Report of: Development Manager

Purpose: To consider Planning Application H14-0449-22

Application Number: H14-0449-22

Description: Erection of a Self-Build Zero Carbon Home (Re-Submission of H14-1299-21)

South Elevation

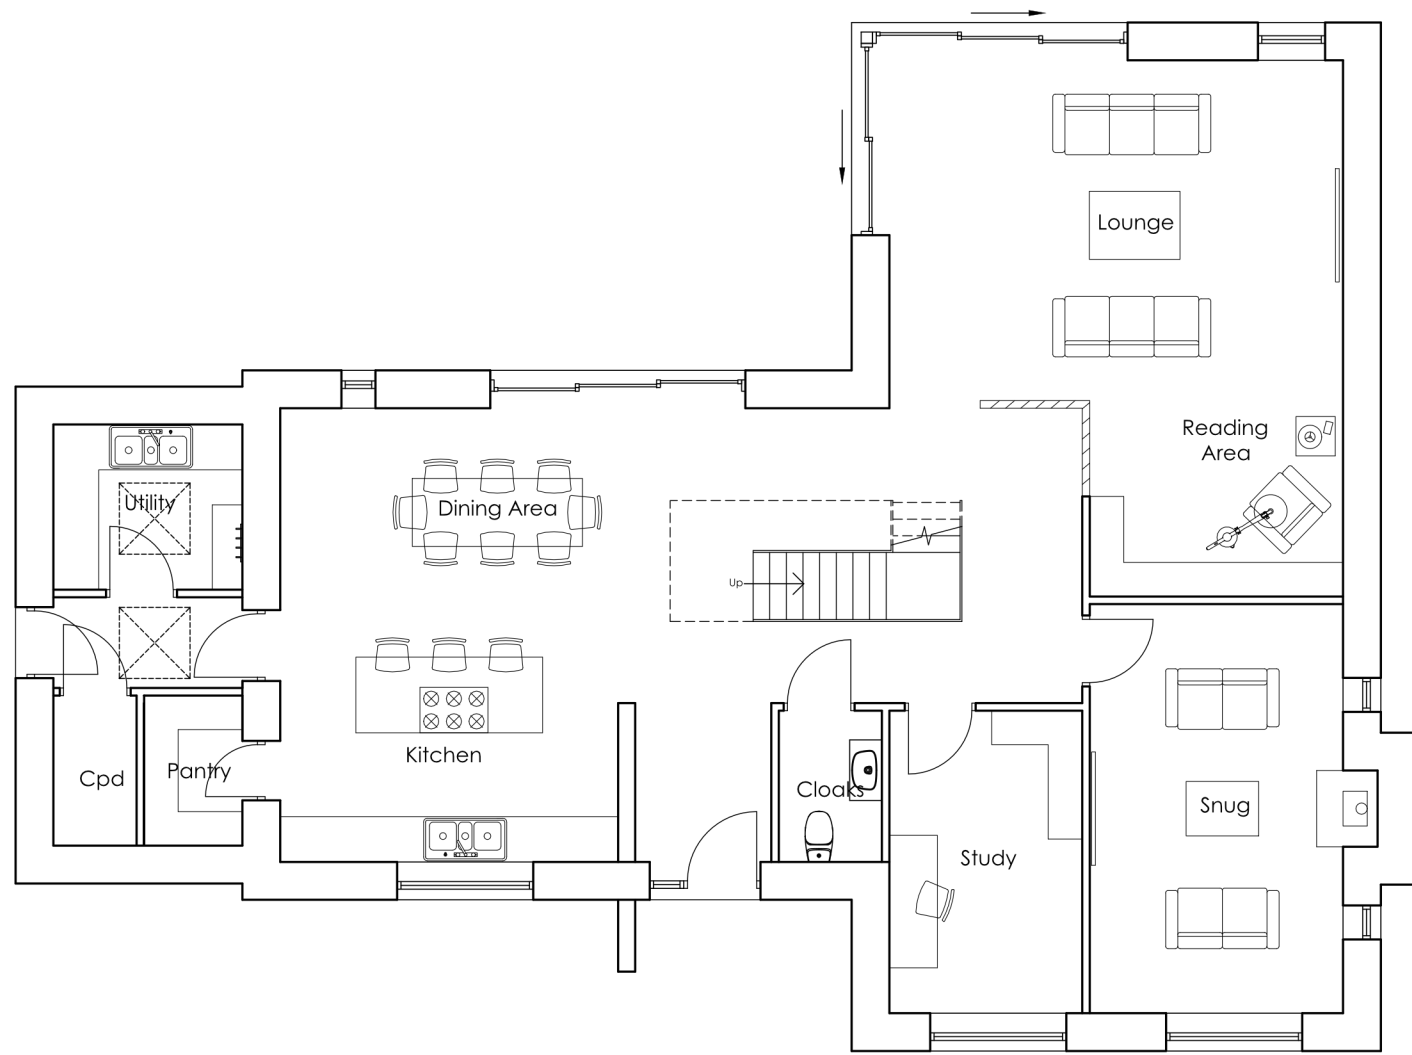
- 7.20 It is accepted that the proposed dwelling is bespoke, however the bulk of the dwelling (i.e. that which is two storey) is for all intents and purposes akin to a standard cross-gable brick construction estate house, just with black zinc cladding and a large chimney breast added. It is noted that the link to the garage has been replaced with a large lean-to that would be solely finished in black cladding, which does not appear residential in design and would be at odds with the main dwellinghouse and surrounding area. The design is not 'truly outstanding' in nature, 'reflecting the highest standards in architecture'. Furthermore, given the overall scale and height of the proposed dwelling (approximately 8.1m to ridge) compared to the neighbouring properties - one single storey in height and one two storey property with a low ridge height, the proposal would have a dominating and overbearing impact on the streetscene. Whilst the energy efficiency/wider sustainability credentials of the proposed dwelling are welcomed, the measures proposed are not so unusual as to be 'exceptional'.

Ground Floor Plan

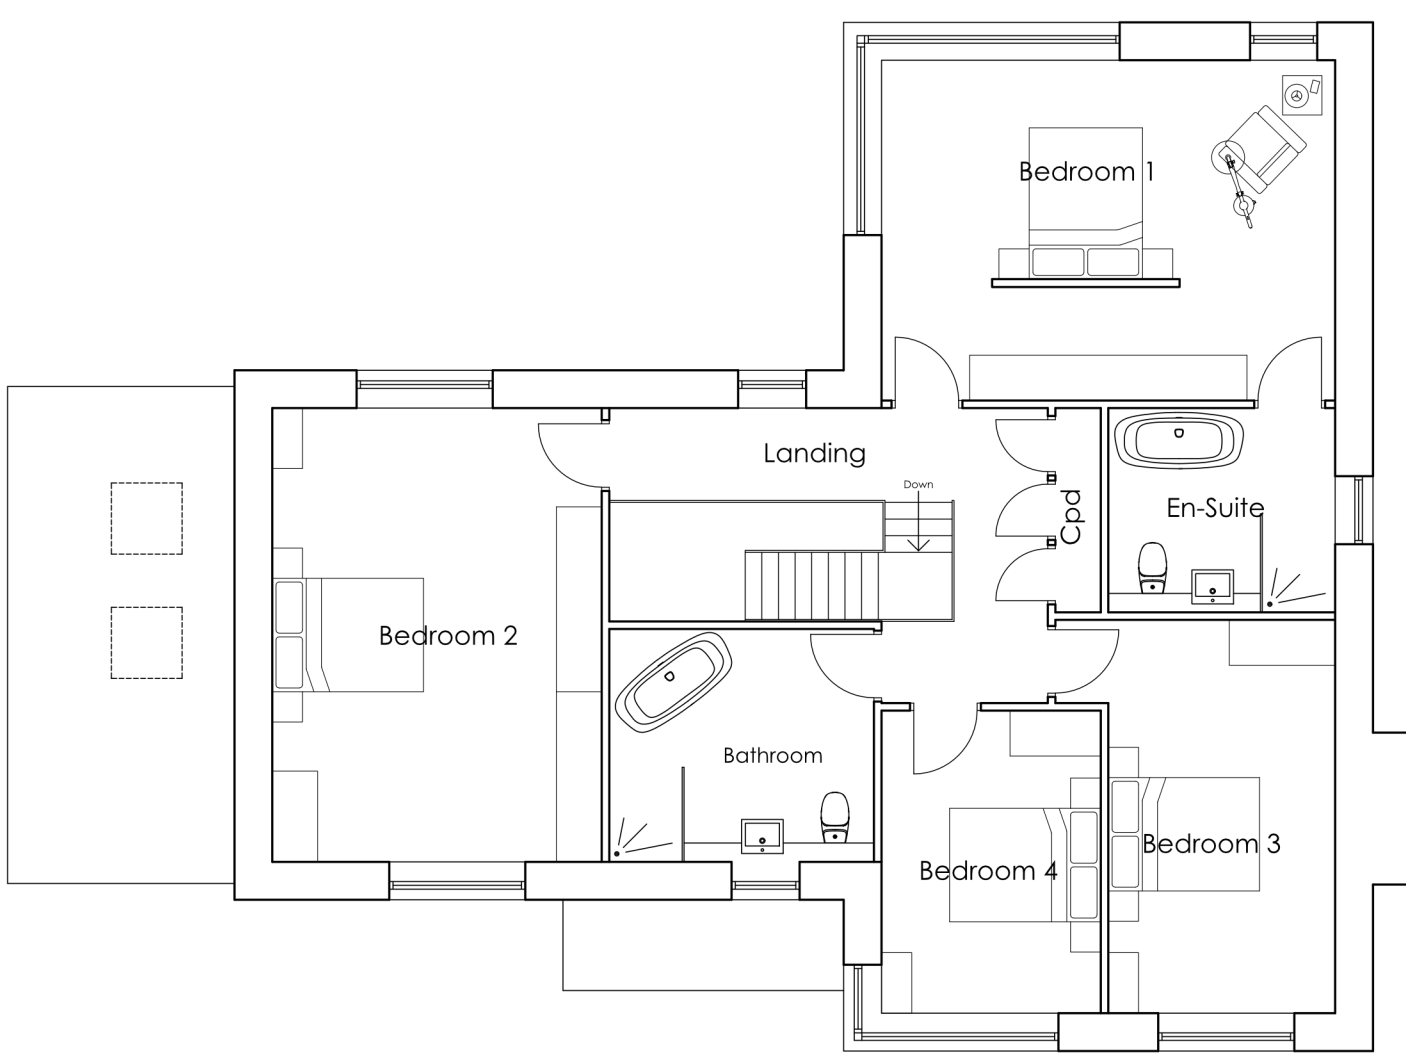
7.33 The proposed dwelling includes a first-floor corner window serving 'Bedroom 1'. Given the siting of the proposed dwelling, the distance to the boundary (approximately 25m) and existing and proposed tree planning/boundary treatments, the proposed window is not considered to result in any overlooking impacts on the neighbouring properties private rear amenity space (Iona, Glenside North).
